KITTITAS COUNTY COMMUNITY DEVELOPMENT SERVICES

December 1, 2020

RE: VA-20-00012 Moore Variance

SITE PLAN

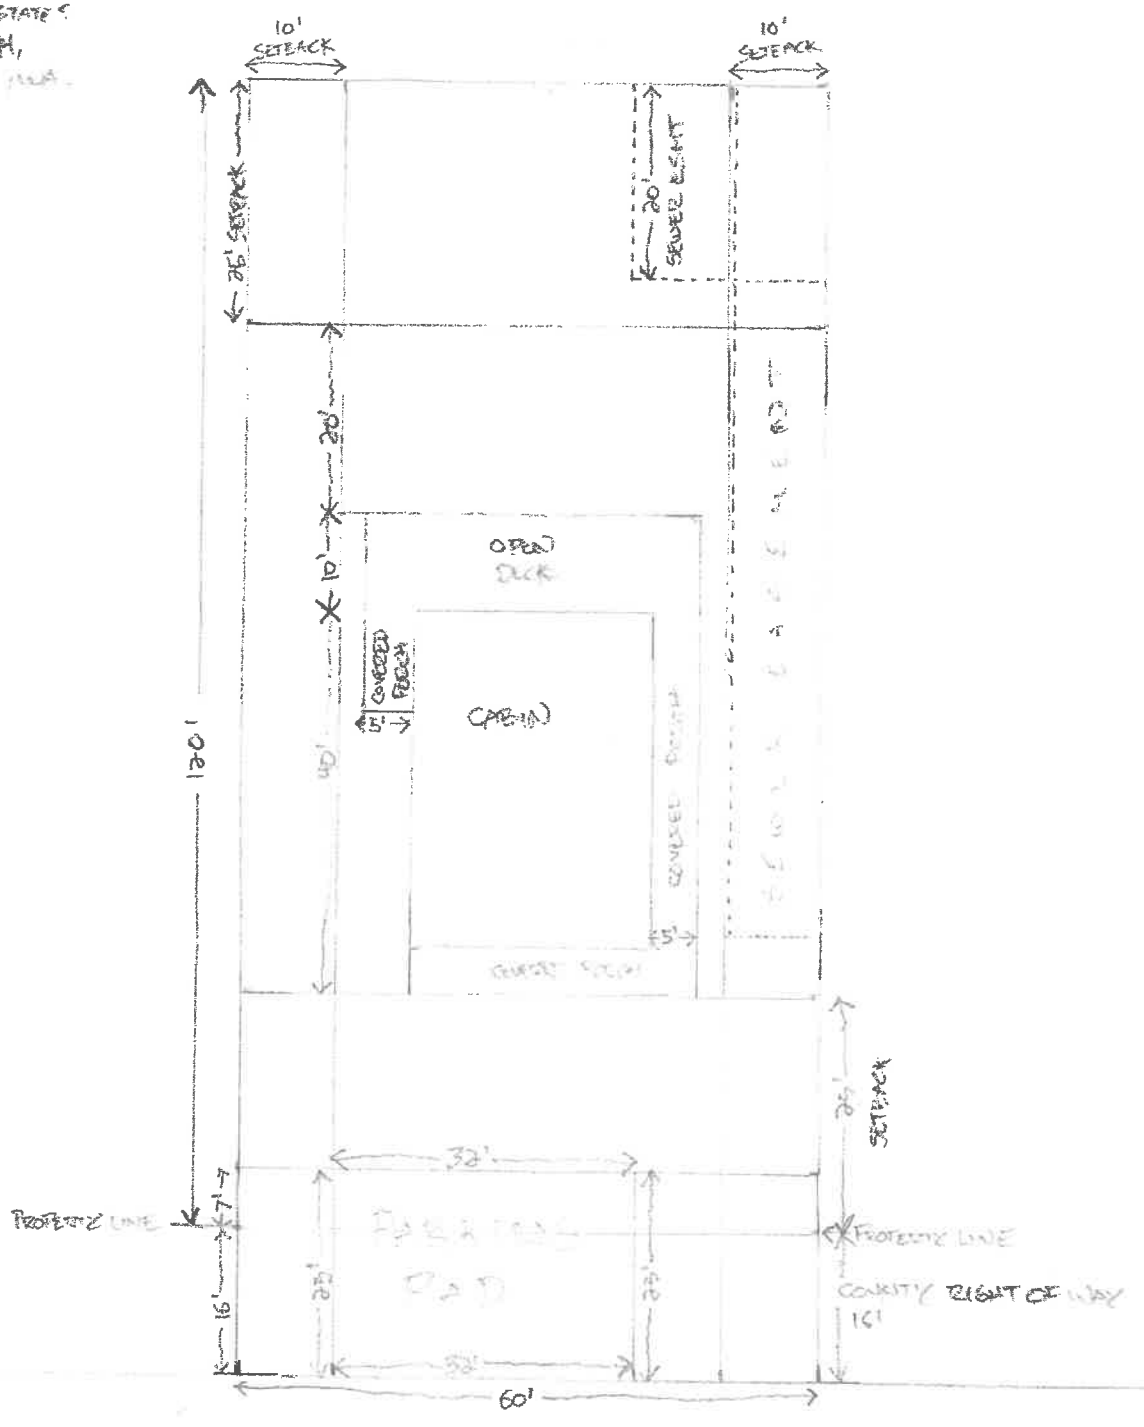
1. The CDS Building division has no opposition to the proposed variance.
2. If approved, the retaining walls both of rock and concrete, will require full engineering design.
